Project:	Union UP4	Date:	25/06/2026
Prepared By:	Richard Watt	Edited:	UG
Status:	For information	Issue:	1
Reference:	10274713		
Topic:	Union UP4 – Responses to GLA comments

This design note has been prepared following a meeting held between the Greater London Authority (GLA) and the UP4 Project team on 10.06.2026, in response to the GLA's request for further clarification on specific aspects of the Union UP4 planning submission.

**A90 - EXTERNAL WORKS
B4 Enlarged Site Plan**

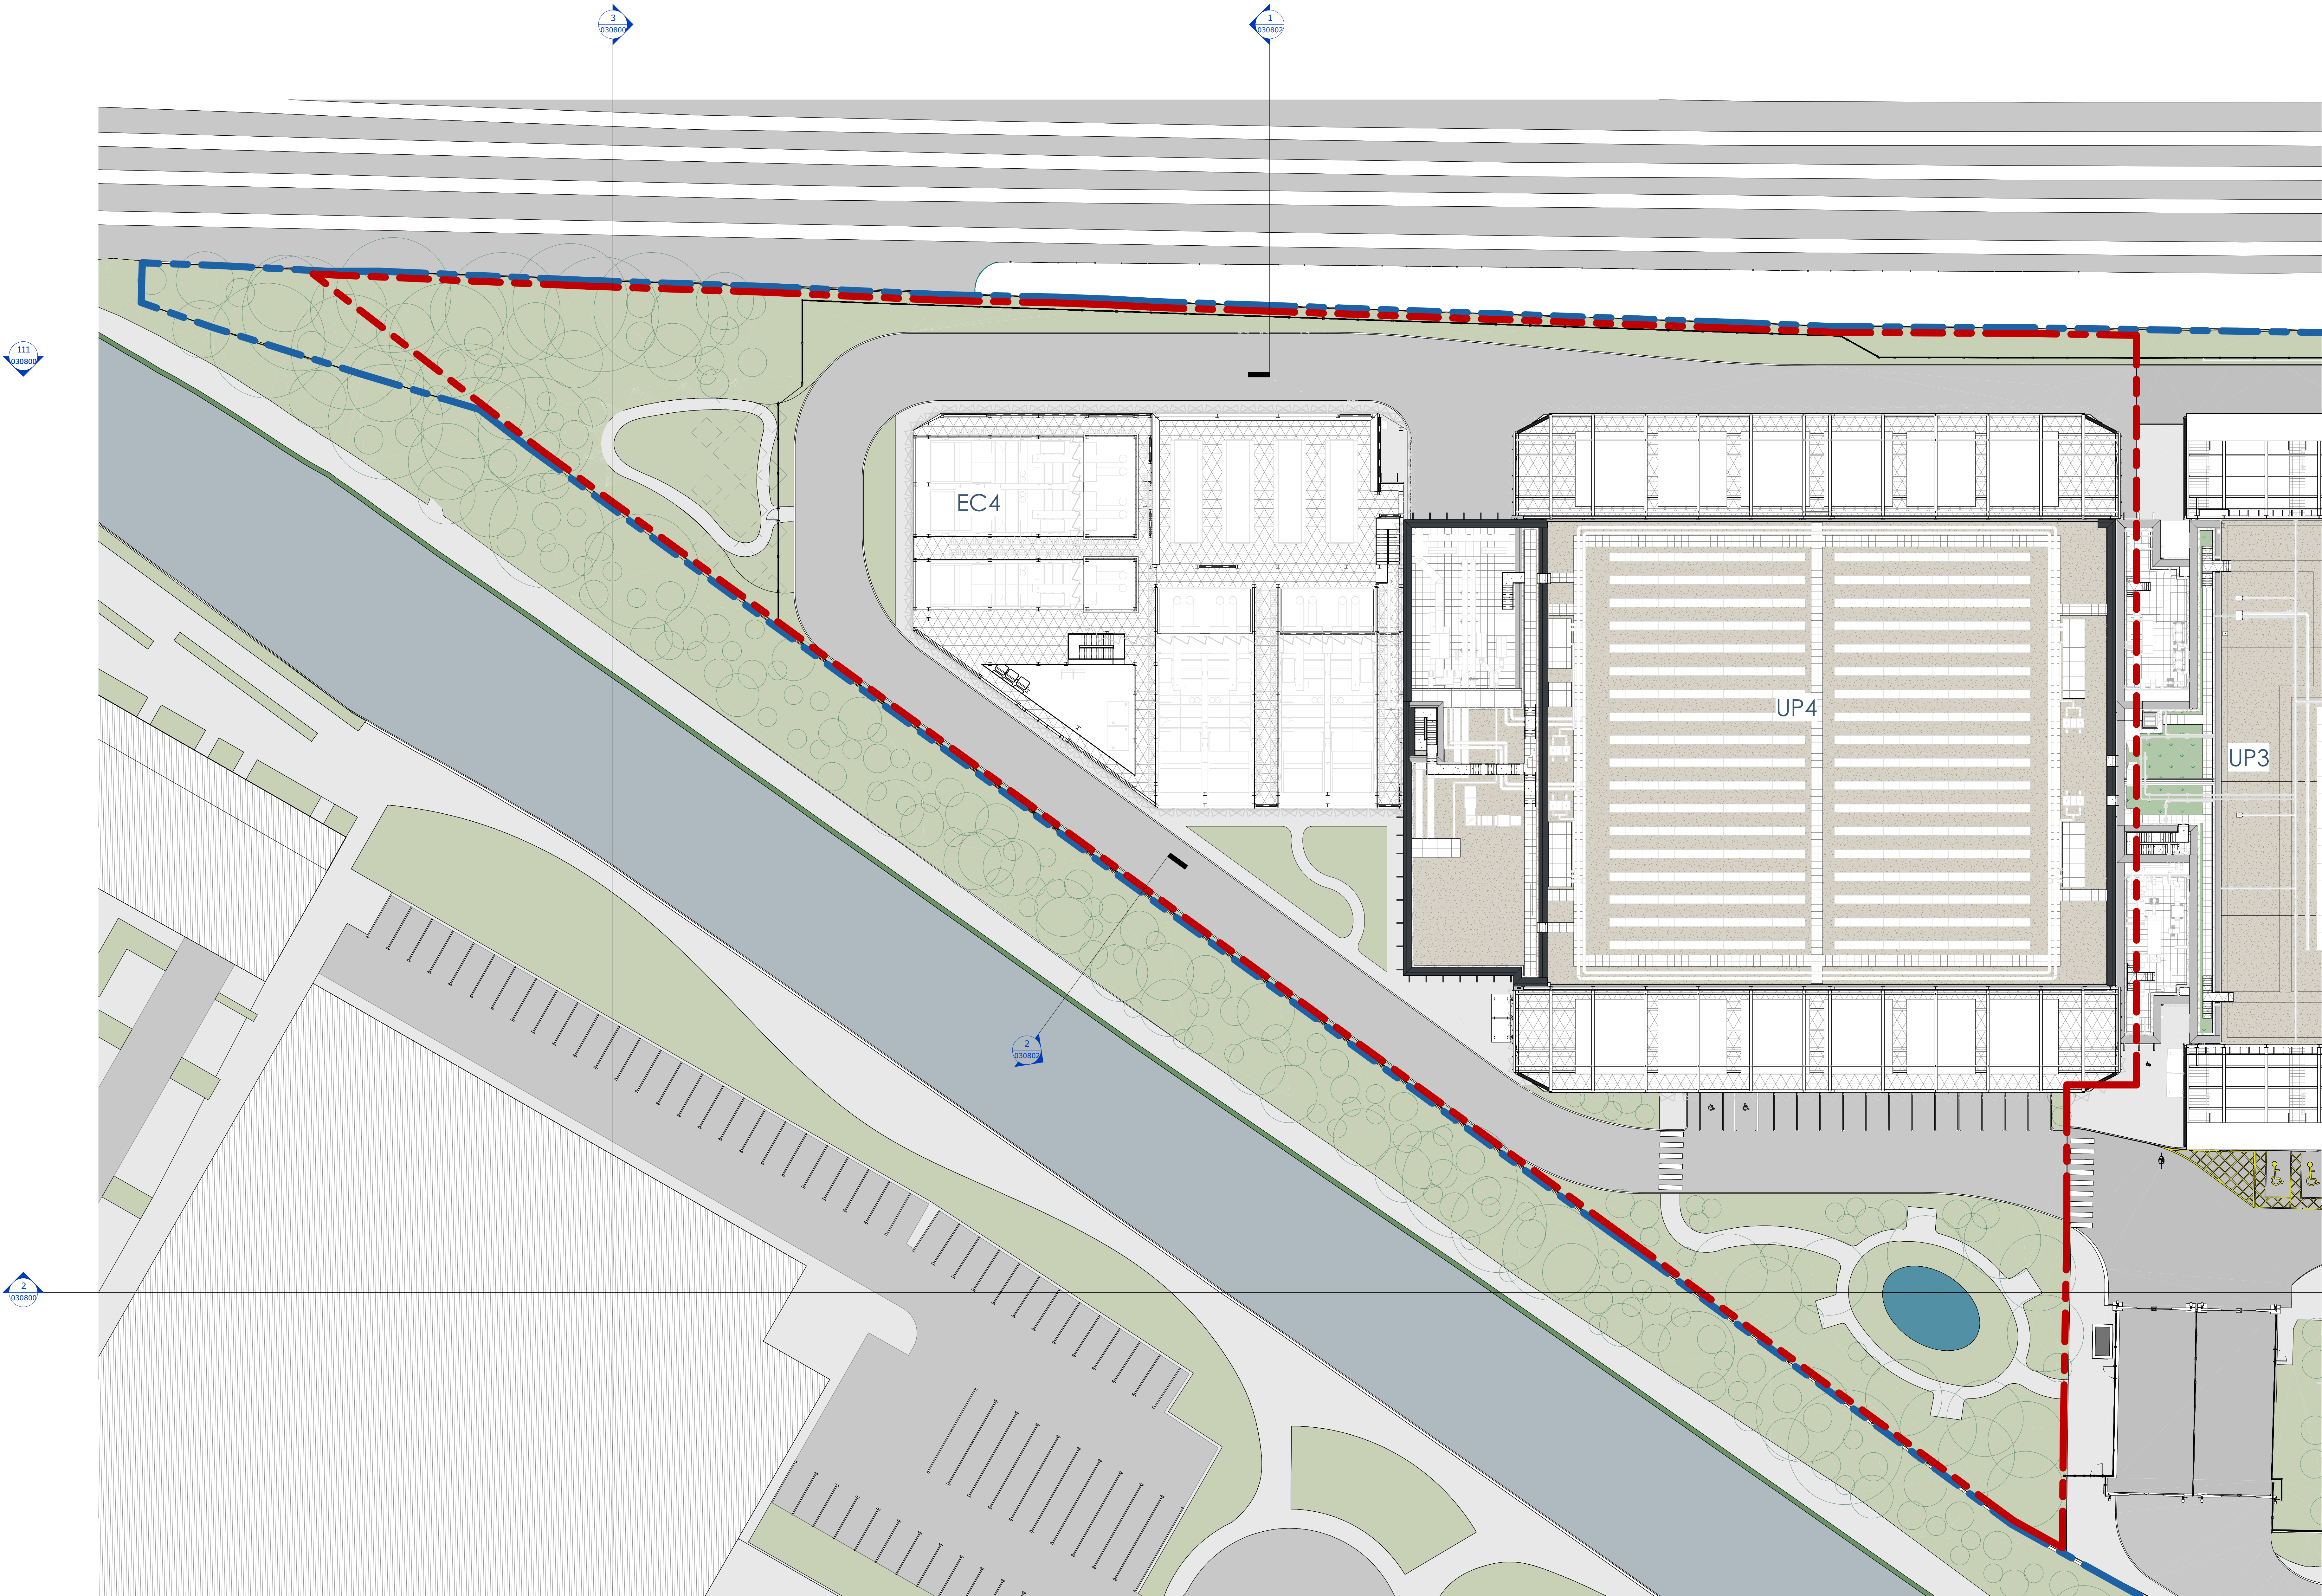
The GLA raised concern that the scheme is not compatible with waste heat recovery.

Please see attached a proposed indicative safeguarded route to a site boundary for connection to a possible future District Heat Network should the data hall cooling technologies change in the future to allow waste heat recovery to be feasible. This was presented in the meeting with the GLA and welcomed by them.
